Please ask for: Ms Iqraa Malik
Email: iqraa.malik@terraquest.co.uk
Telephone: 01212341390
Our Ref: A/12/21/L
Your Ref:
Date: 1st February 2021

Listed Building Consent for Alterations, Extension or Demolition of a Listed Building

Development: Minor exterior and interior alterations to Listed property. The work includes 3 x new windows, back elevation, demolition of an interior dividing wall, and other minor works.

Location: Waterton House Arundel Road Angmering BN16 4JR

GROUND FLOOR PLAN - Before and after, alterations highlighted

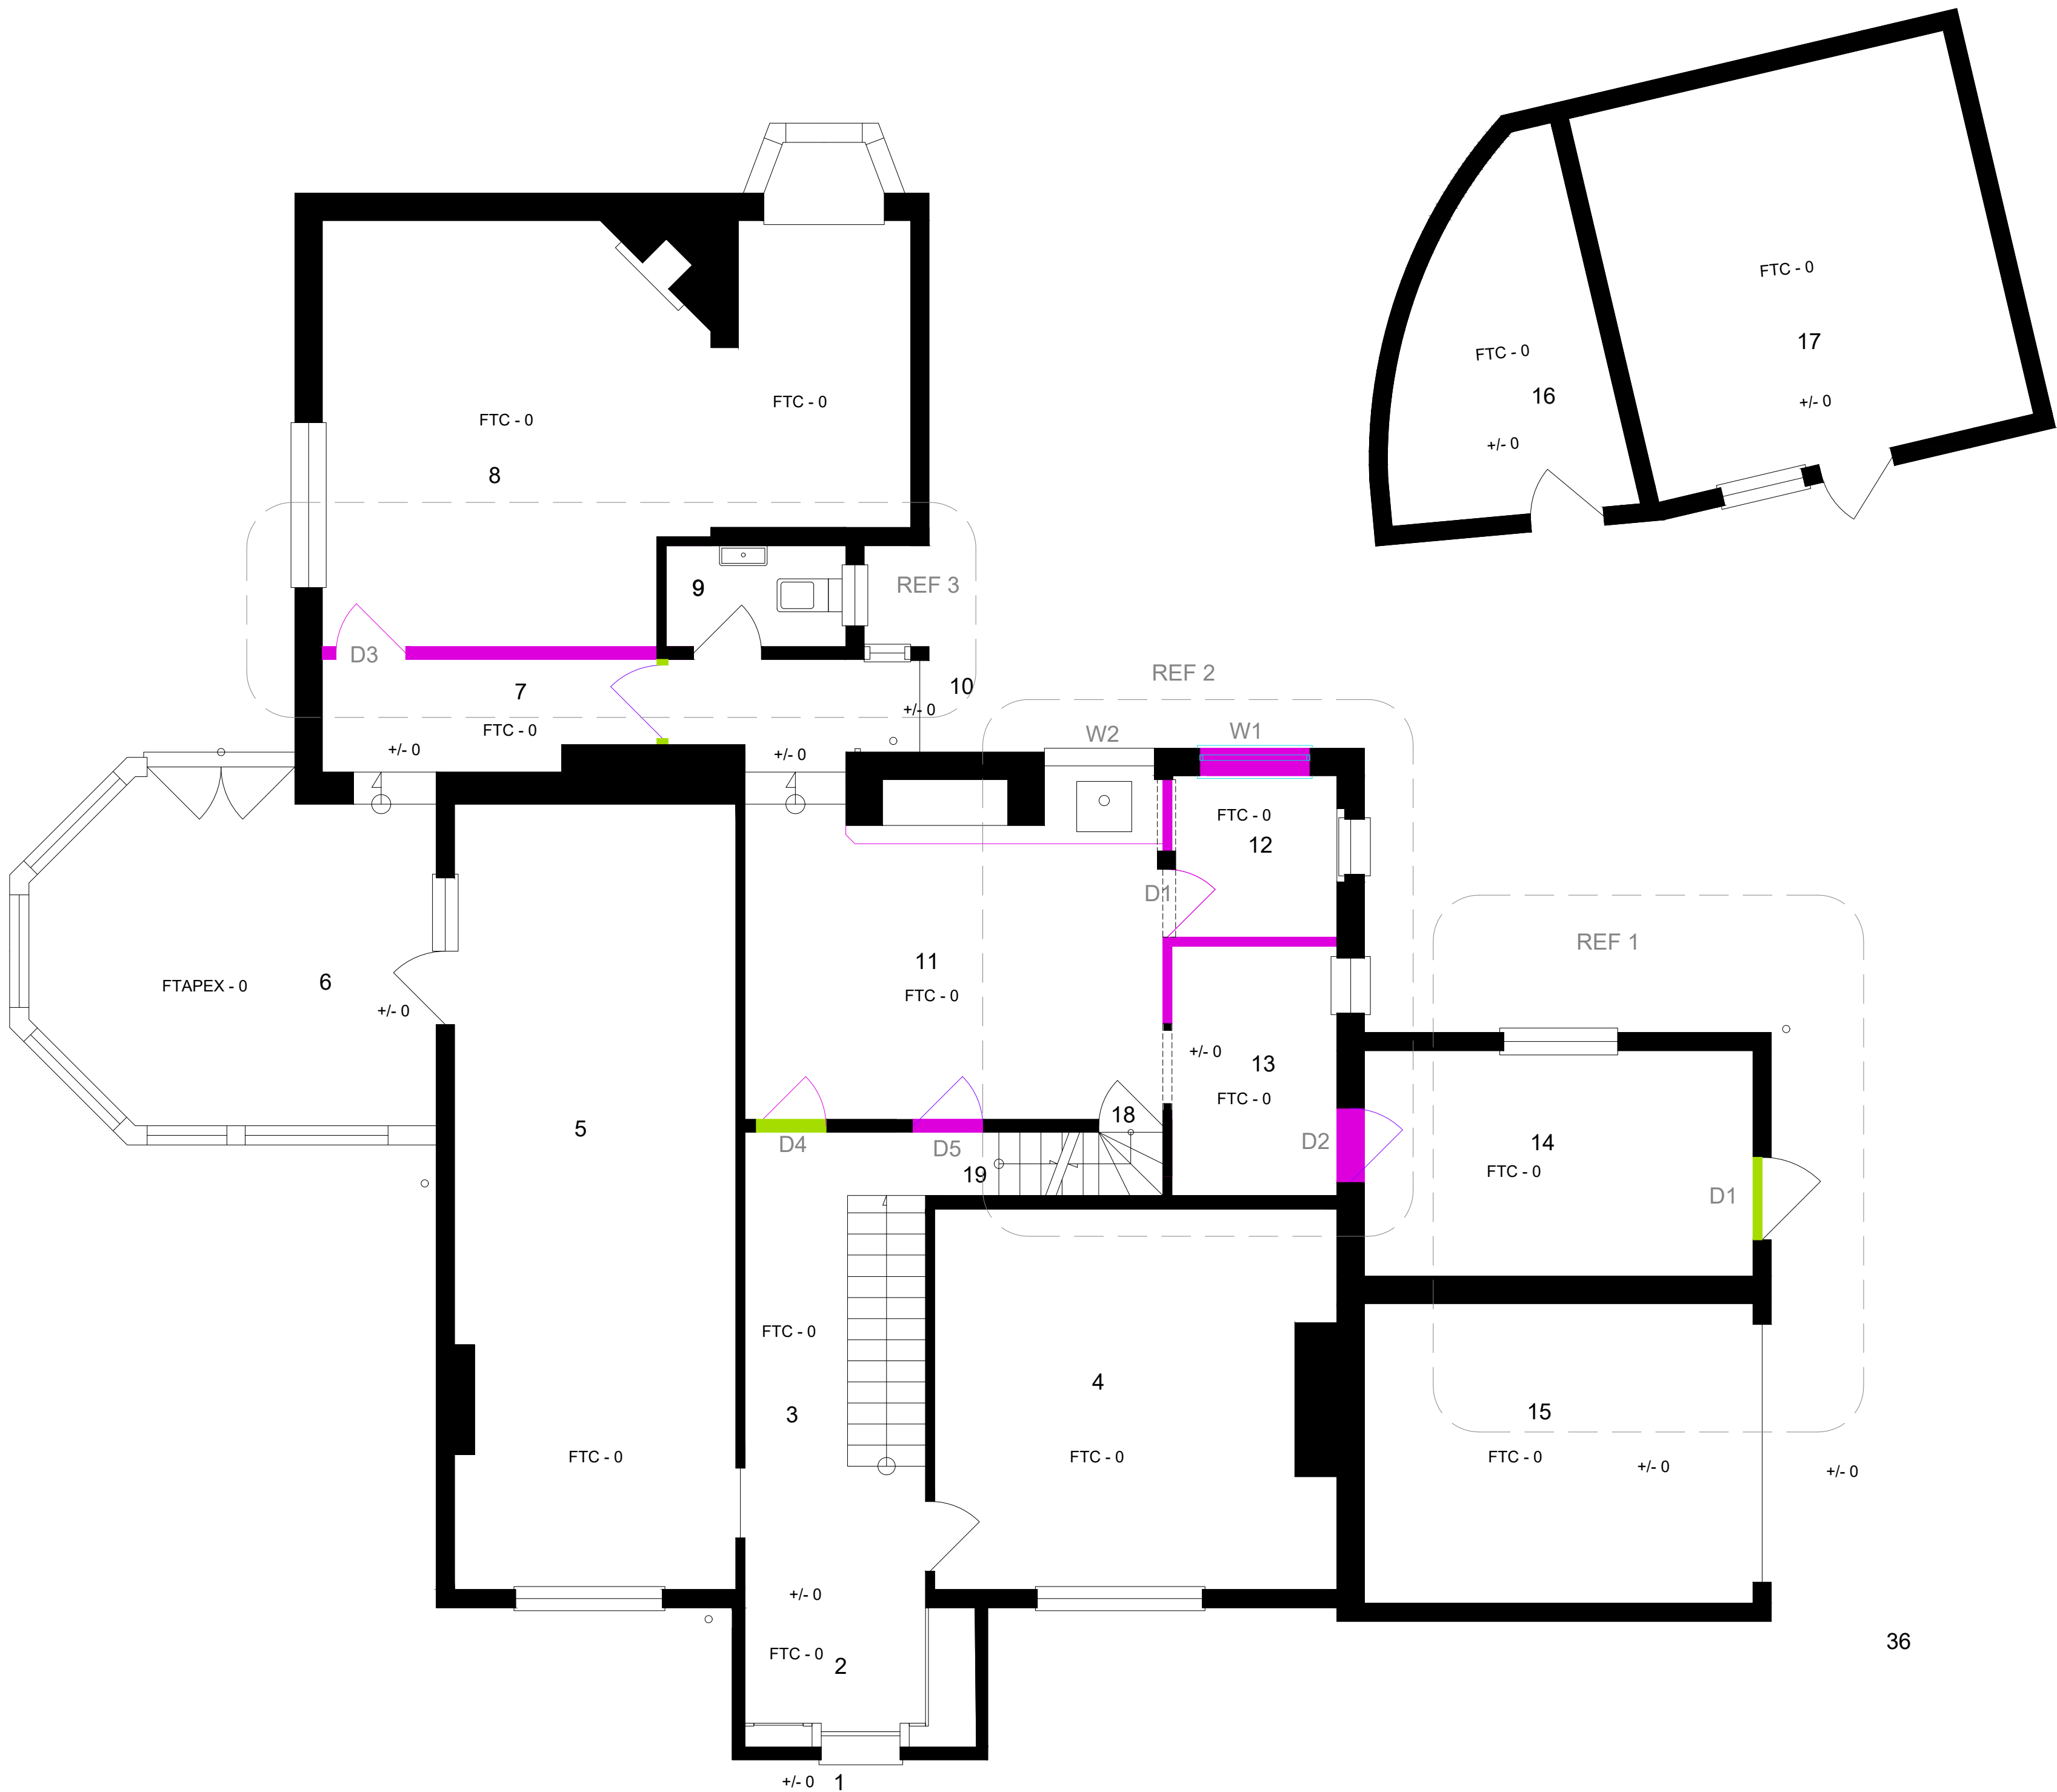
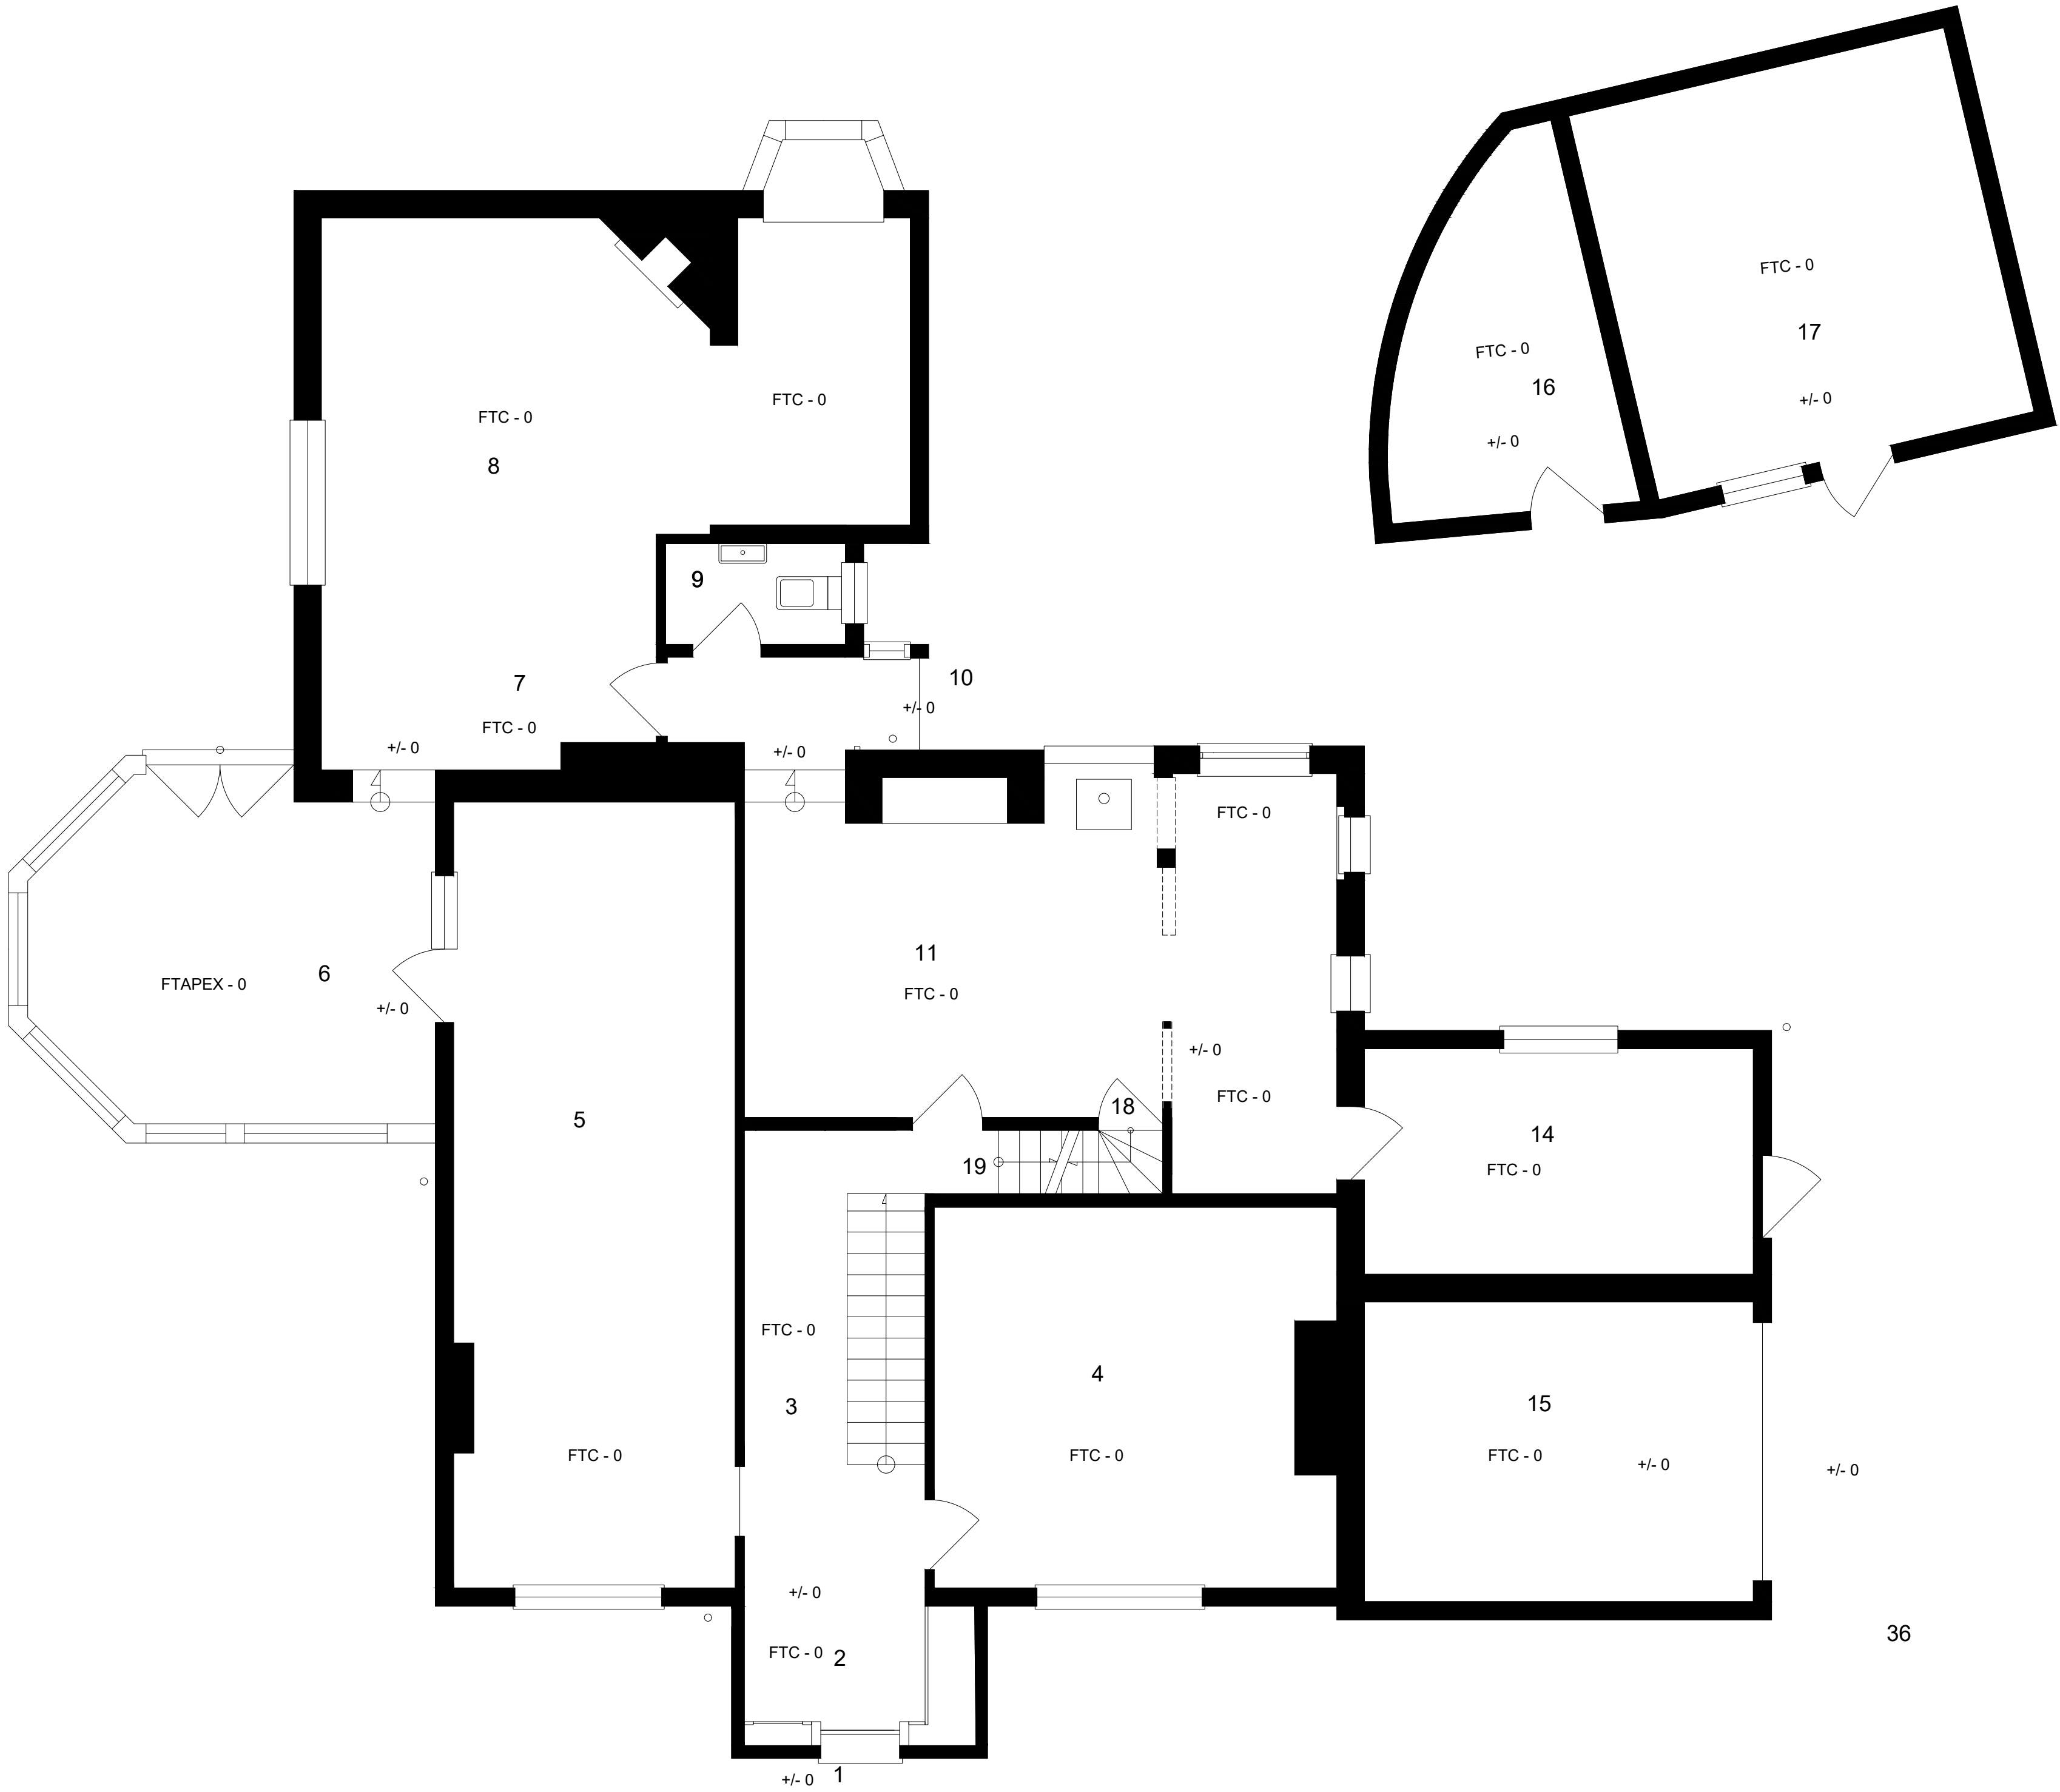
Windows: The application form states 3 windows however the plans are showing 2. Please confirm and amend as necessary
